MONA OFFSHORE WIND PROJECT

Schedule of Changes to Plans F02

Application Reference: EN010137

Document Reference: S_D1_29

Drawing Title:
LAND PLAN - ONSHORE
SHEET NUMBER: 11

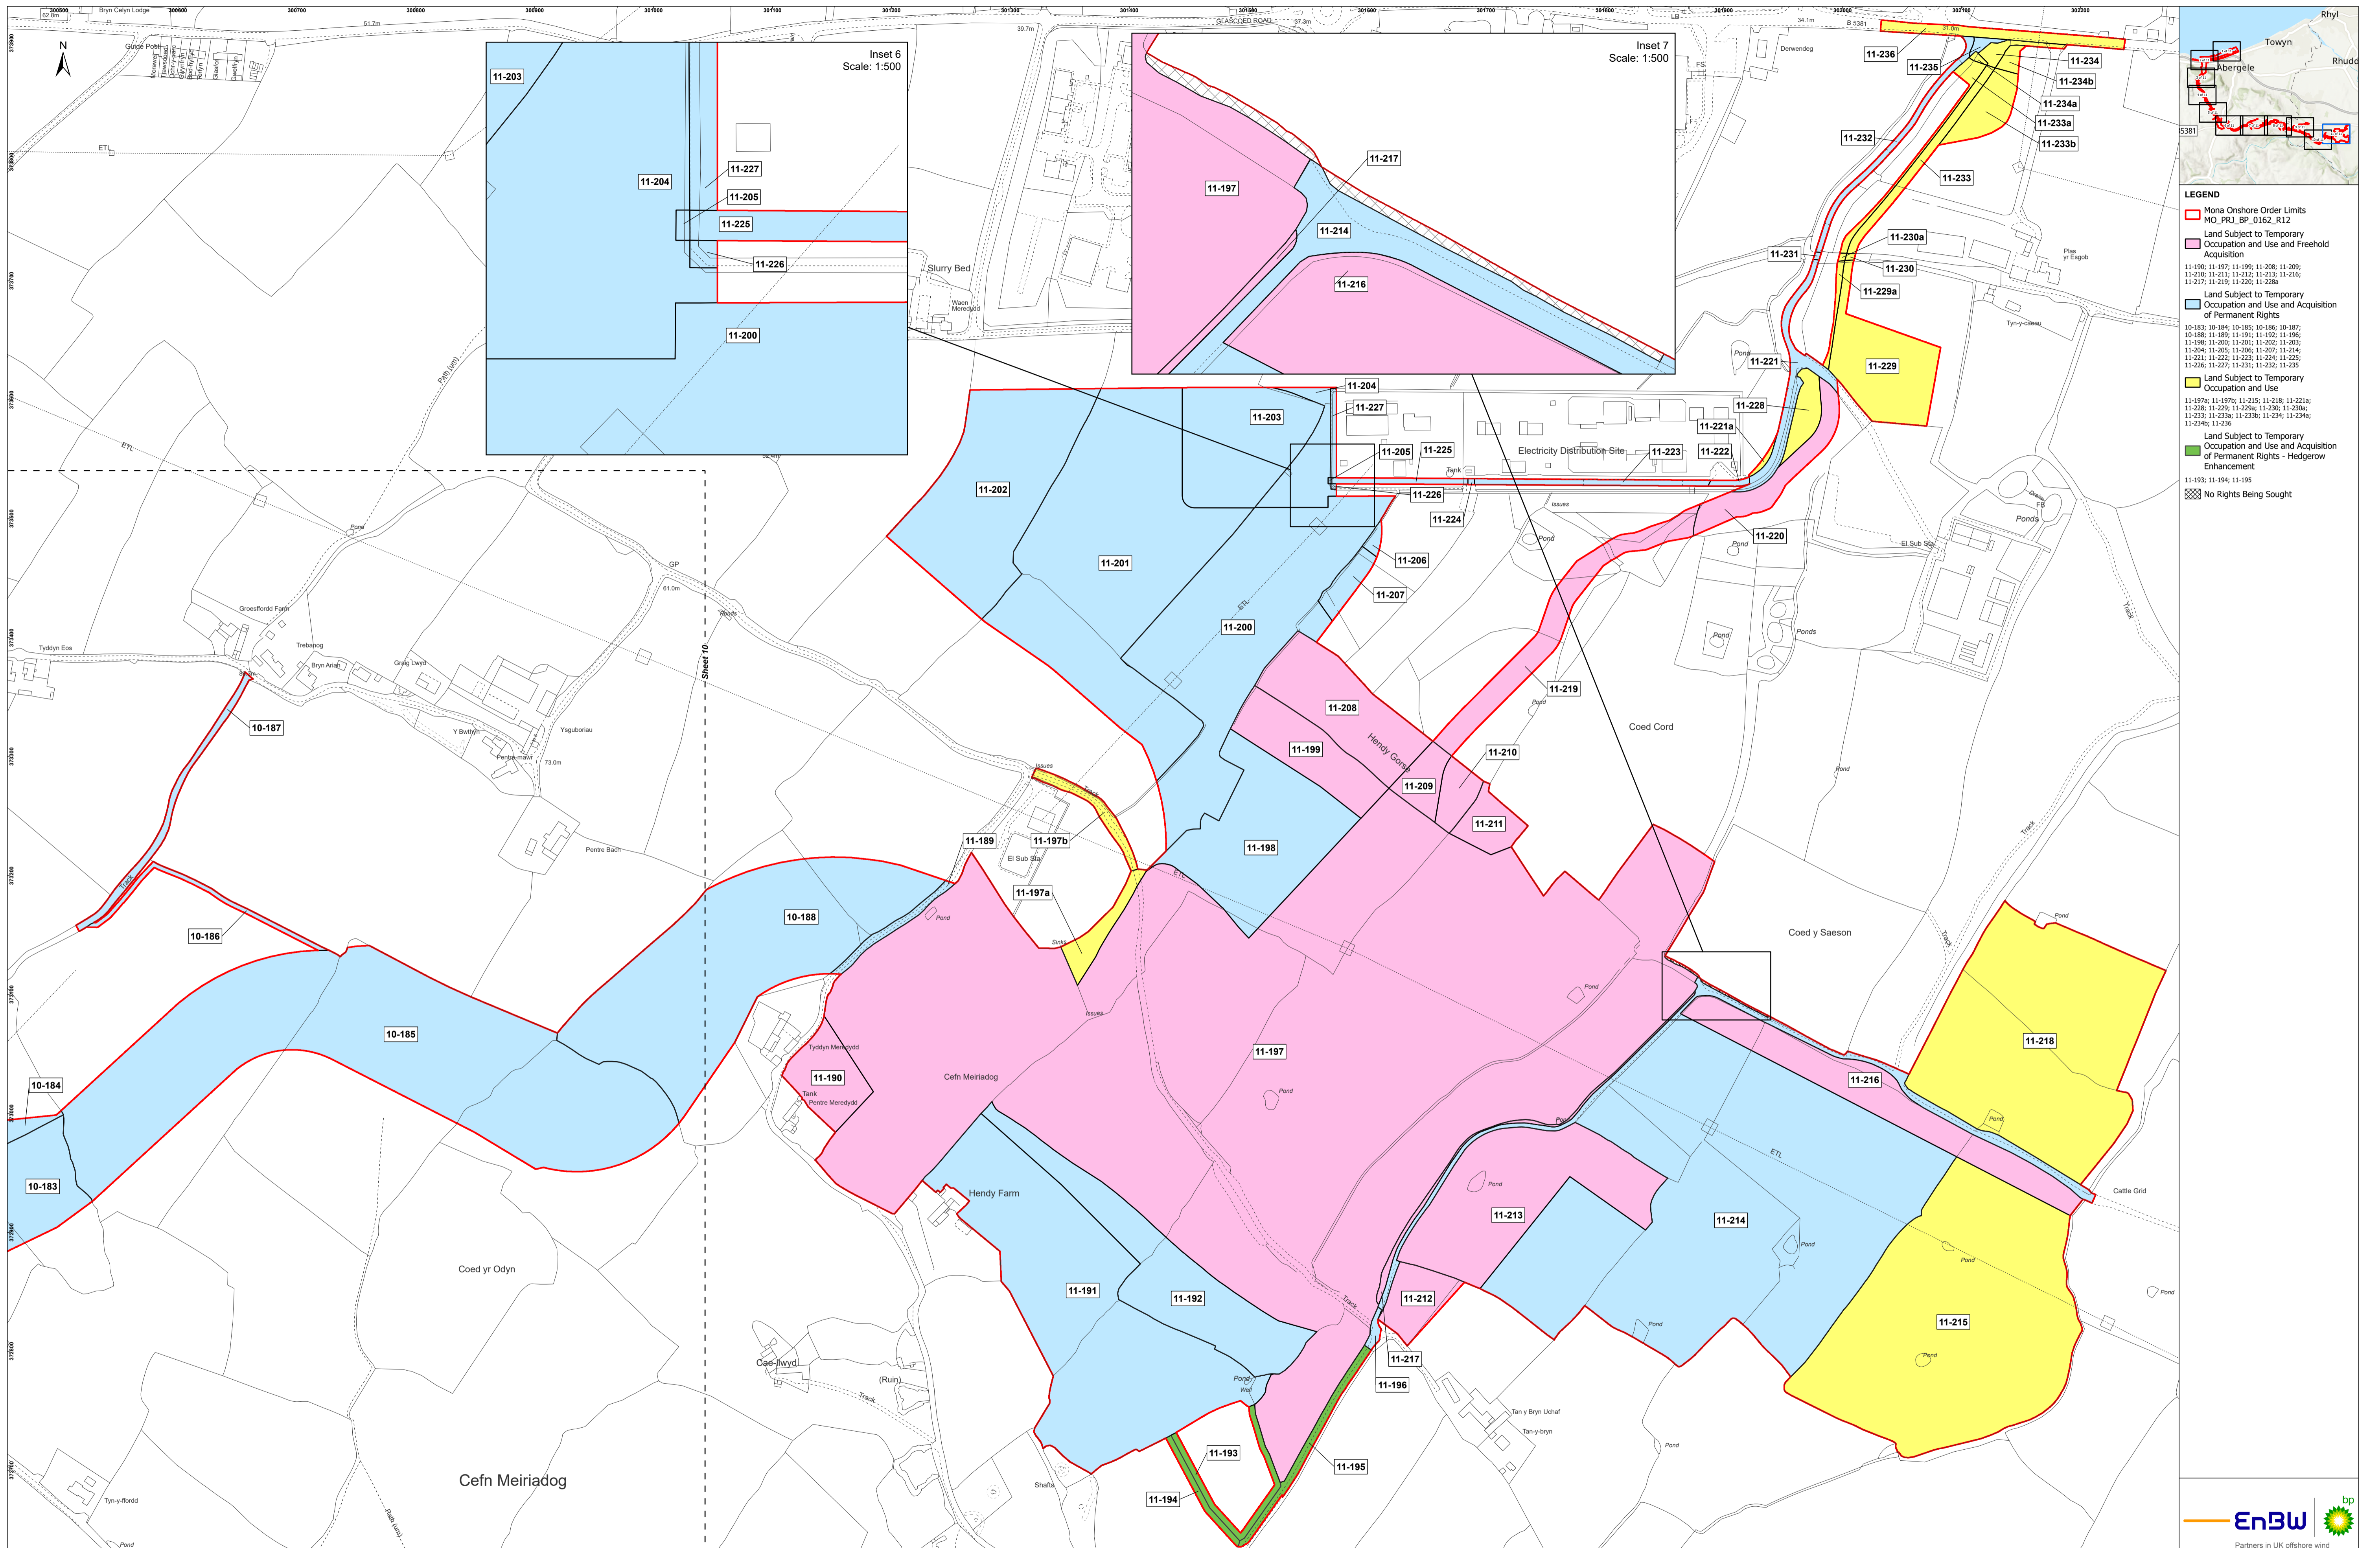
11	11-197	11-197a, 11-197b	31/10/2024	Plot split on plans, new label added and key updated to include new plot number	The change application has created a new plot	Rev V03
11	11-221	11-221a	31/10/2024	Plot split on plans, new label added and key updated to include new plot number	The change application has created a new plot	Rev V03
11	11-229	11-229a	31/10/2024	Plot split on plans, new label added and key updated to include new plot number	The change application has created a new plot	Rev V03
11	11-230	11-230a	31/10/2024	Plot split on plans, new label added and key updated to include new plot number	The change application has created a new plot	Rev V03
11	11-233	11-233a, 11-233b	31/10/2024	Plot split on plans, new label added and key updated to include new plot number	The change application has created a new plot	Rev V03
11	11-234	11-234a, 11-234b	31/10/2024	Plot split on plans, new label added and key updated to include new plot number	The change application has created a new plot	Rev V03
